Subject: Rezoning Petition Review

Rezoning Petition #: 22-109

Location of Property: Approximately 2.09 acres located on the northeast side of The Plaza, south of Bridgeport Dr and west of Barrington Dr.

RZ-1

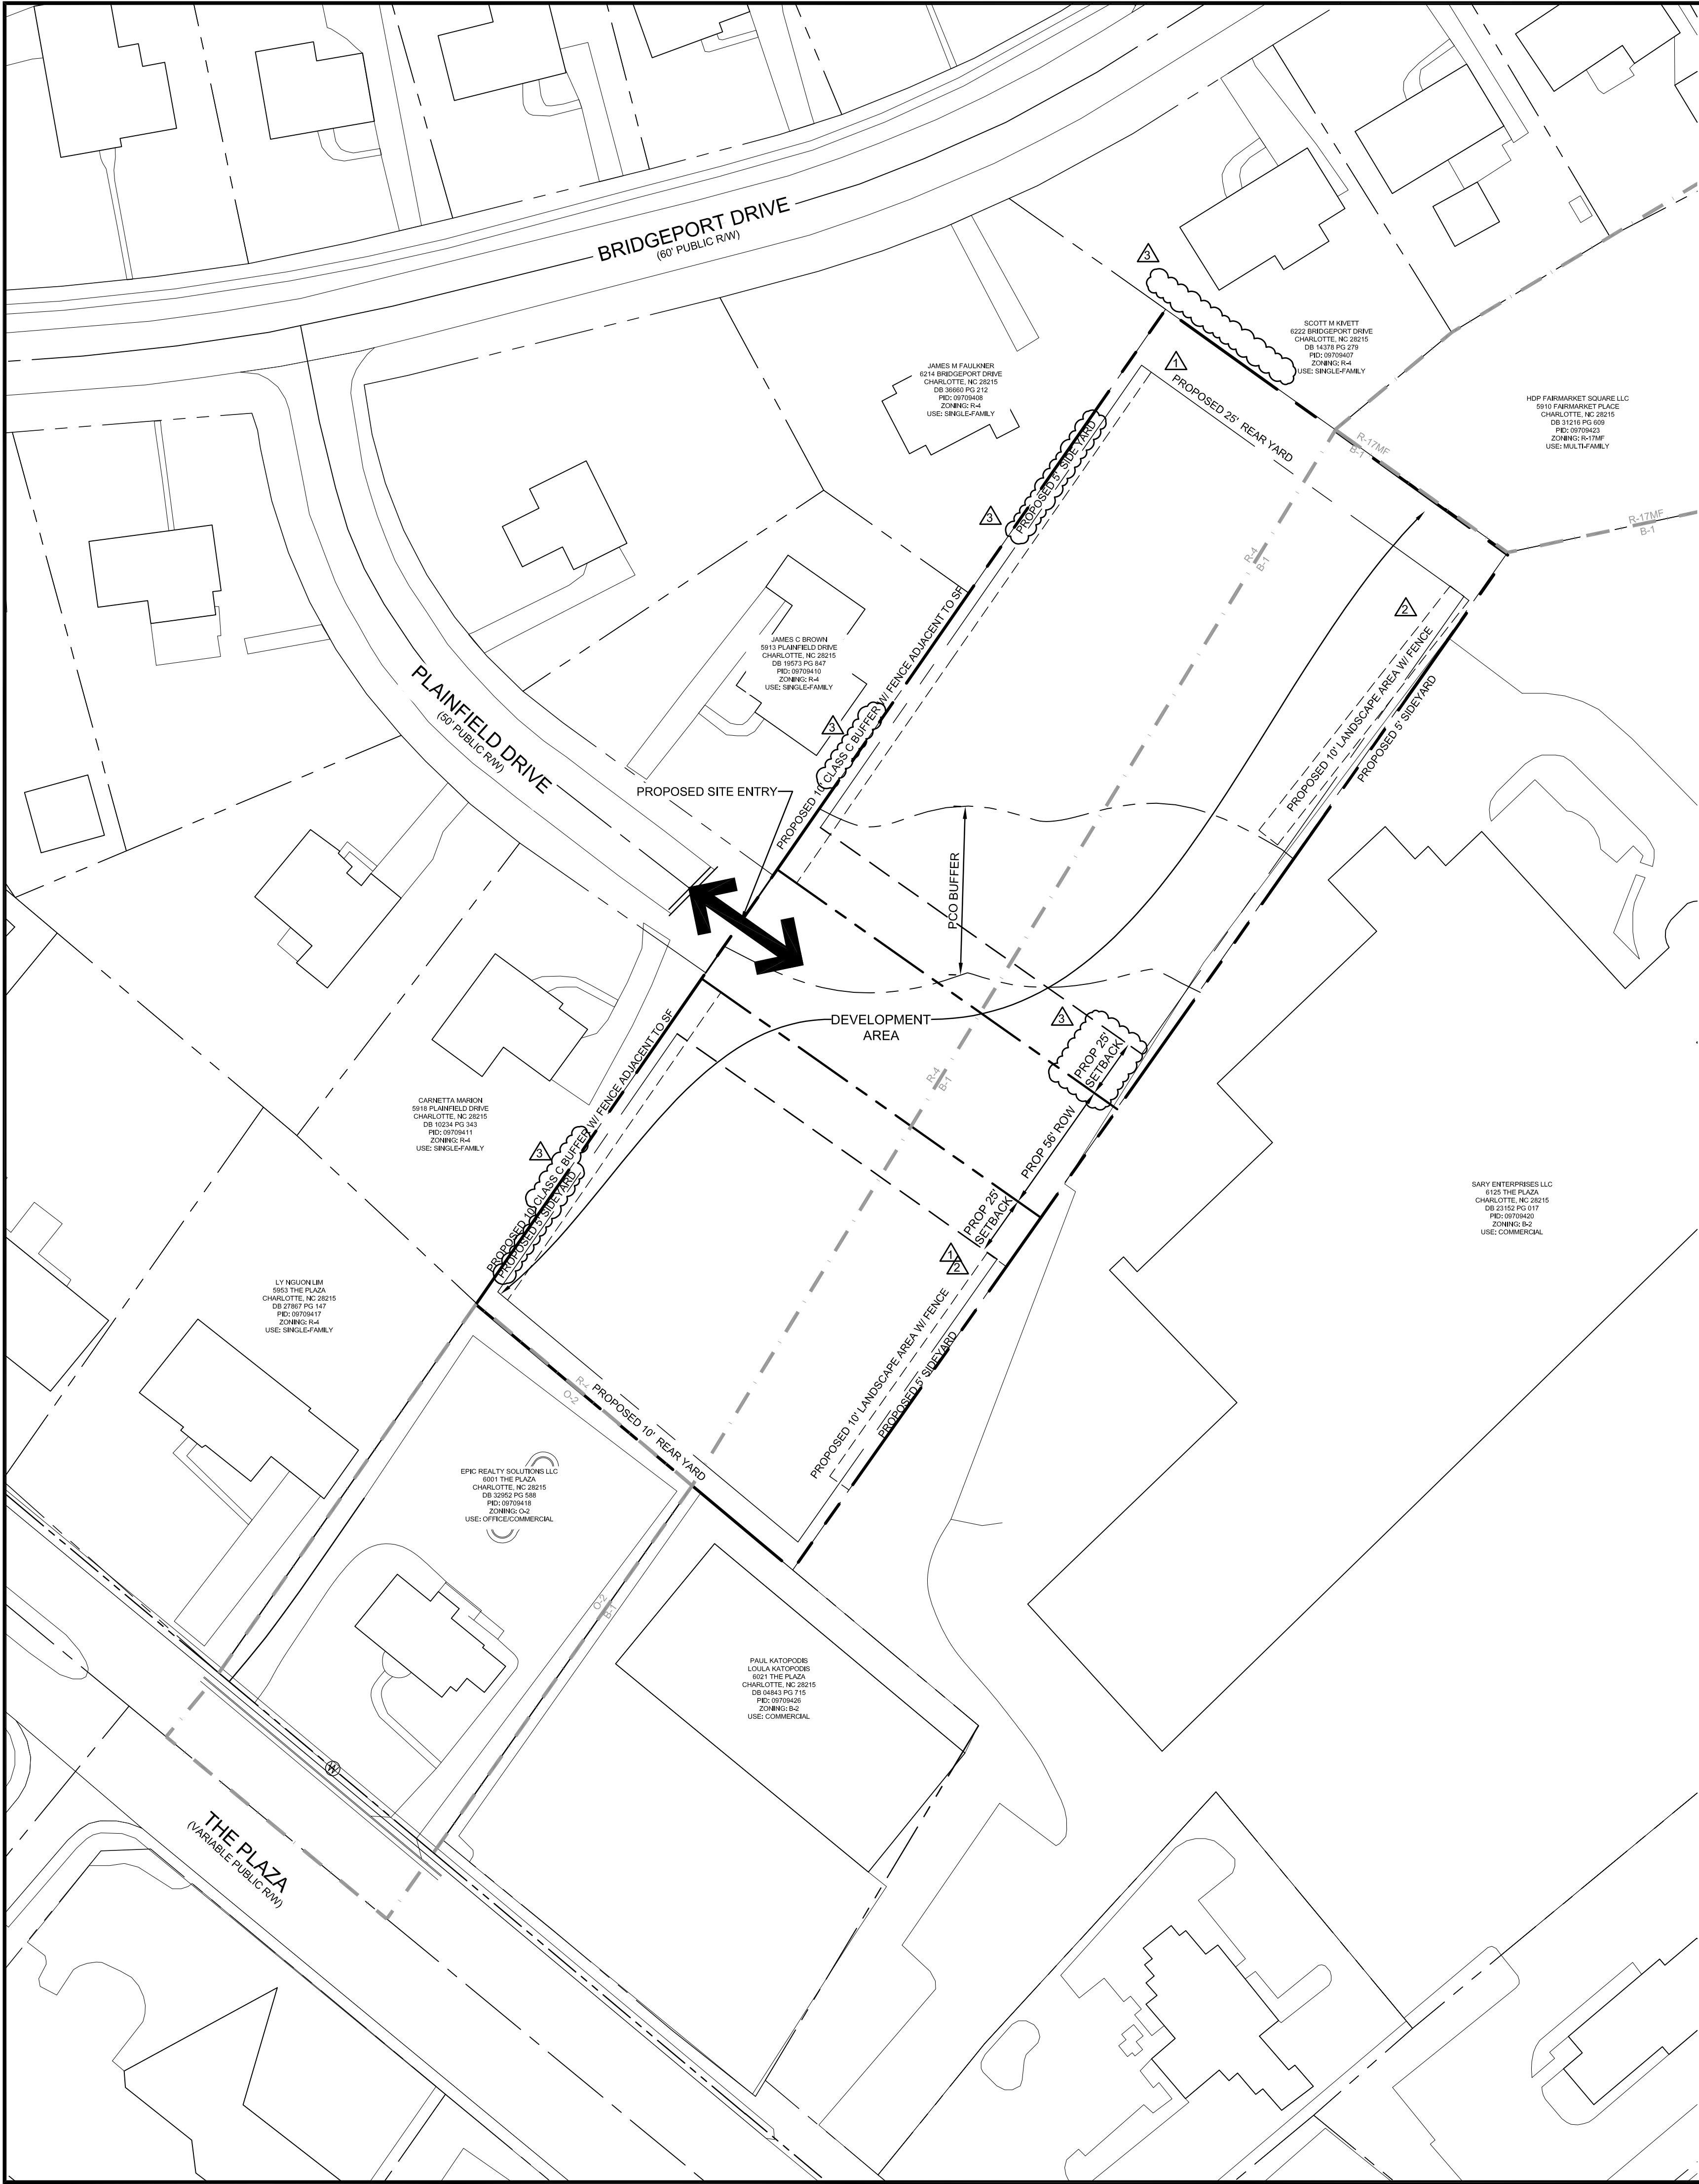
City of Charlotte GIS data indicates a 30-ft PCSO Buffer crossing the site. Any increase of impervious area within SWIM/PCSO buffers may not be allowed and is not approved with the rezoning process. Please include the following note under Environmental Features: *“Development within any SWIM/PCSO Buffer shall be coordinated with and subject to approval by Charlotte-Mecklenburg Storm Water Services and mitigated if required by City ordinance. Petitioner acknowledges intermittent/perennial stream delineation reports are subject to review and approval upon submission of development plans for permitting and are not approved with rezoning decisions.”*
